Our reference: ECM 9378704  
Contact: Robert Craig  
Telephone: (02) 4732 7593

21 December 2020

**Request for Comments – SSD-10479 – 200 Aldington Road Industrial Estate, Lots 30-32 DP 258949 & Lots 20-23 DP 255560, 106-228 Aldington Road, Kemps Creek**

Figure 9 – Locations of Proposed Basin A and Basin B

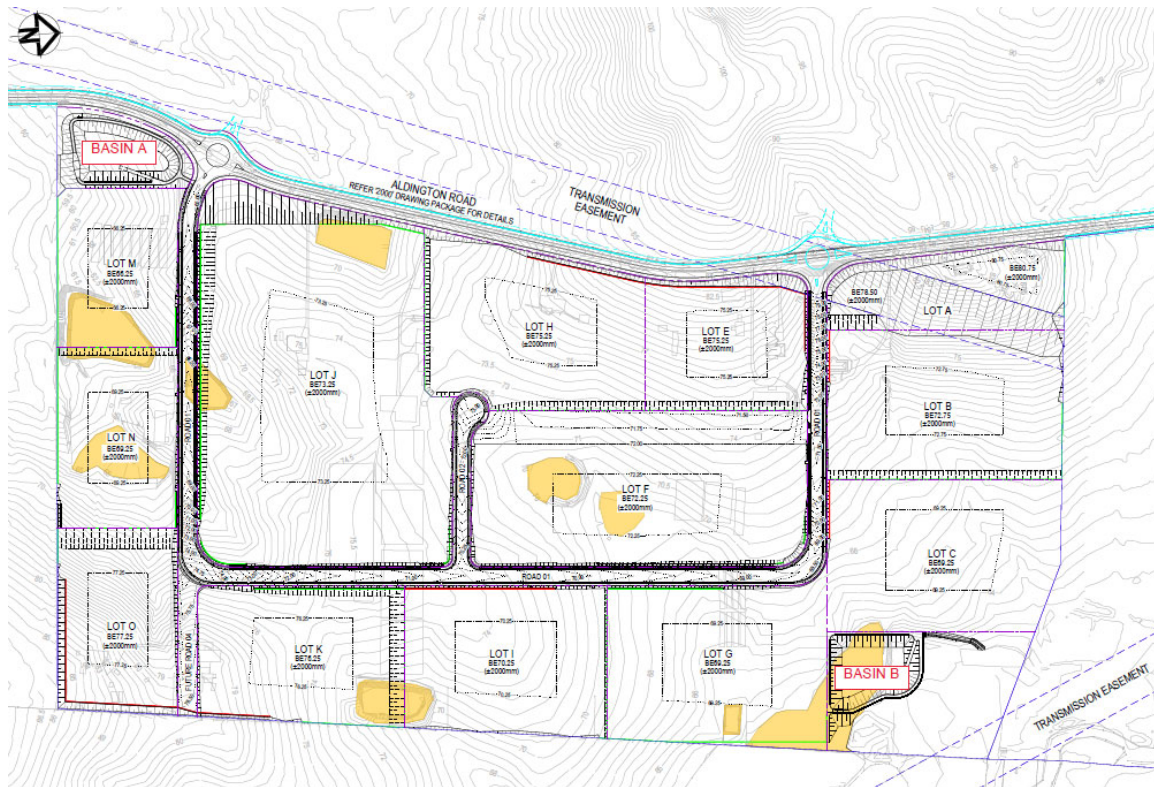
As no on-lot OSD is to be provided, the proposed bioretention basins will also have capacity for OSD. As a result, the basins will be designed to store stormwater at depths in the order of 3m above the filter media. This approach is not consistent with Council's guidelines and as such Council is not supportive of this design approach. In this regard, the system should be reconfigured to ensure that maximum depths of extended detention are minimised. In addition, low flow diversions should be in place to ensure that only intended design flows are directed to the bioretention system (i.e. only low flows should be diverted to the bioretention filter area and high flows should be directed to the separate OSD storage).

With regard to Basin 2, this basin should not be located within the RE2 zoned land. In relation to the design of the basins more generally, it is recommended that the design and configuration of the stormwater treatment basins be reconsidered. This should include, but not be limited to, the inlet design and flow configuration, depth of maximum ponding, sizing of basins, provision for access for maintenance and vegetation densities and species. In this regard, there are many technical design guidelines available to assist in any revised design, including on Council's website.

Project **PROPOSED STAGE 1 LANDSCAPE PLAN**  
Address **200 ALDINGTON ROAD, KEMPS CREEK NSW**  
Drawing Title **STAGE 1 - AREA 5 LANDSCAPE PLAN**  
Client **FKC ESTATE**

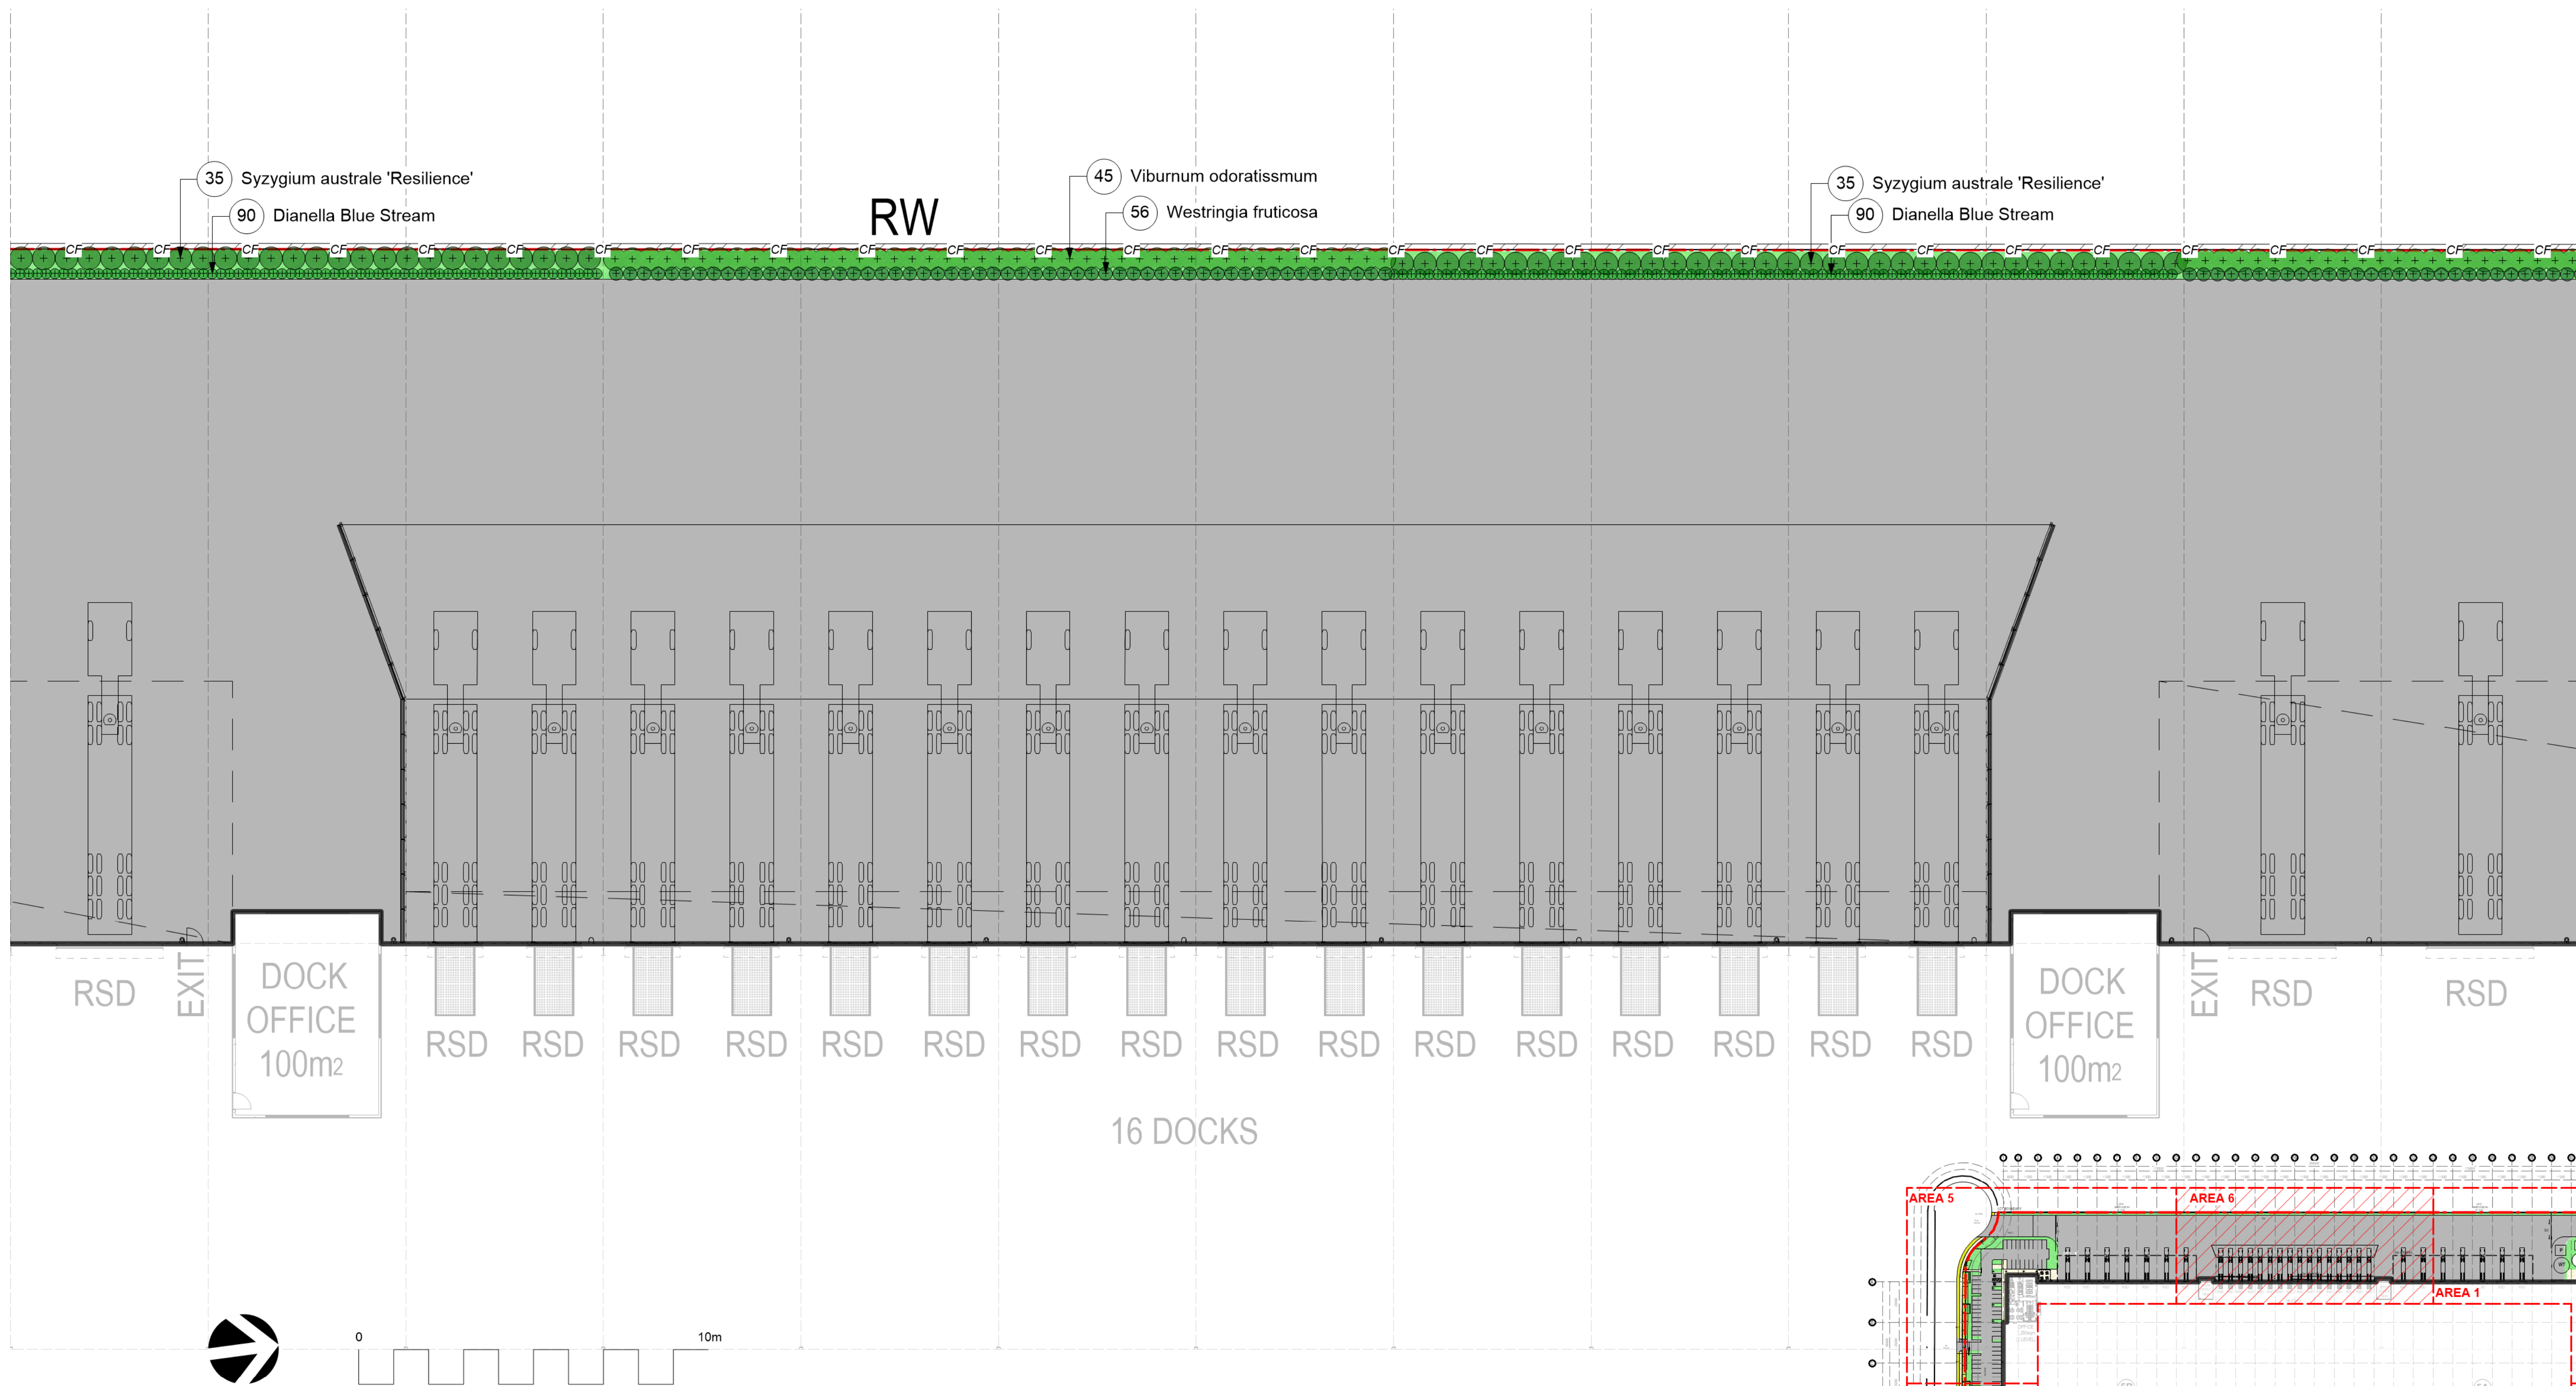
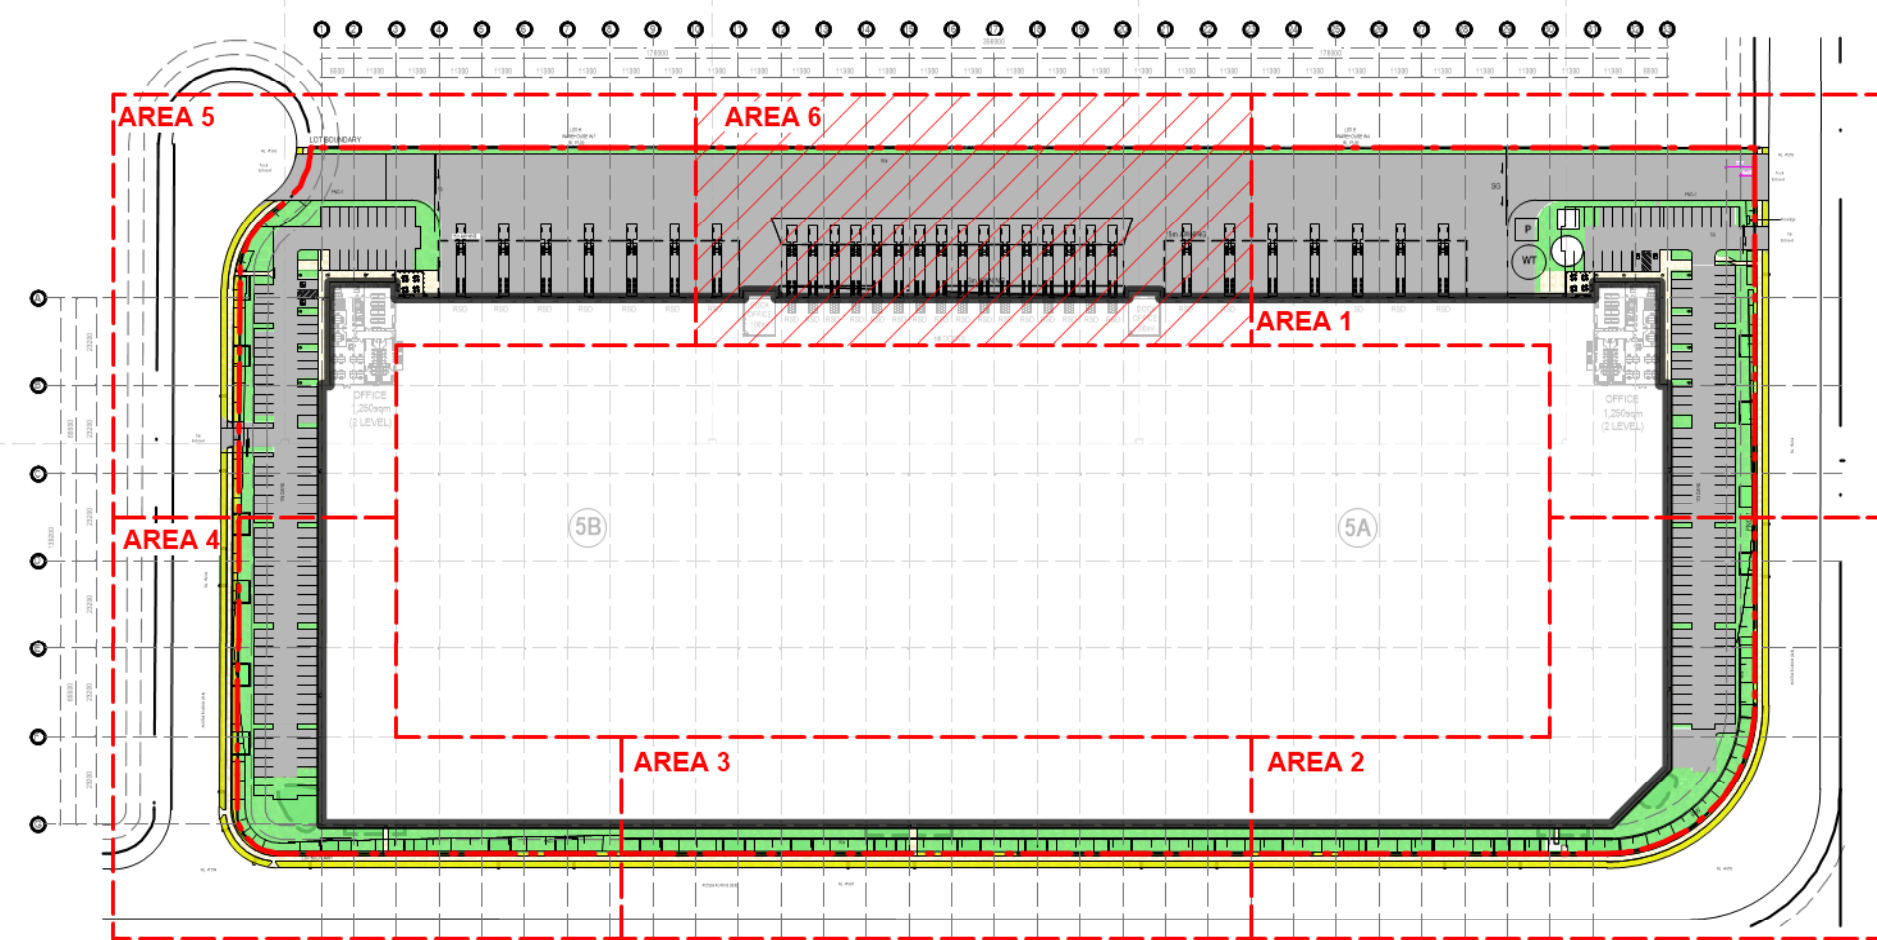
- The tree planting detail is not to industry standard. Further, the detail is not suitable for all of the pot sizes proposed.

- Setback landscaping does not reflect the preference for the landscape character implied in the landscape documentation (i.e. consistent and full depth informal planting). There is an inadequate quantity of tree canopy in setbacks, shown typically as one tree per 25m-40m length. This does not achieve required cooling and amenity. Setbacks should have a consistent tall, dense and canopied address to the street for cooling and to reduce the bulk and scale of built forms.

- The tree planting detail is not to industry standard. Further, the detail is not suitable for all of the pot sizes proposed.
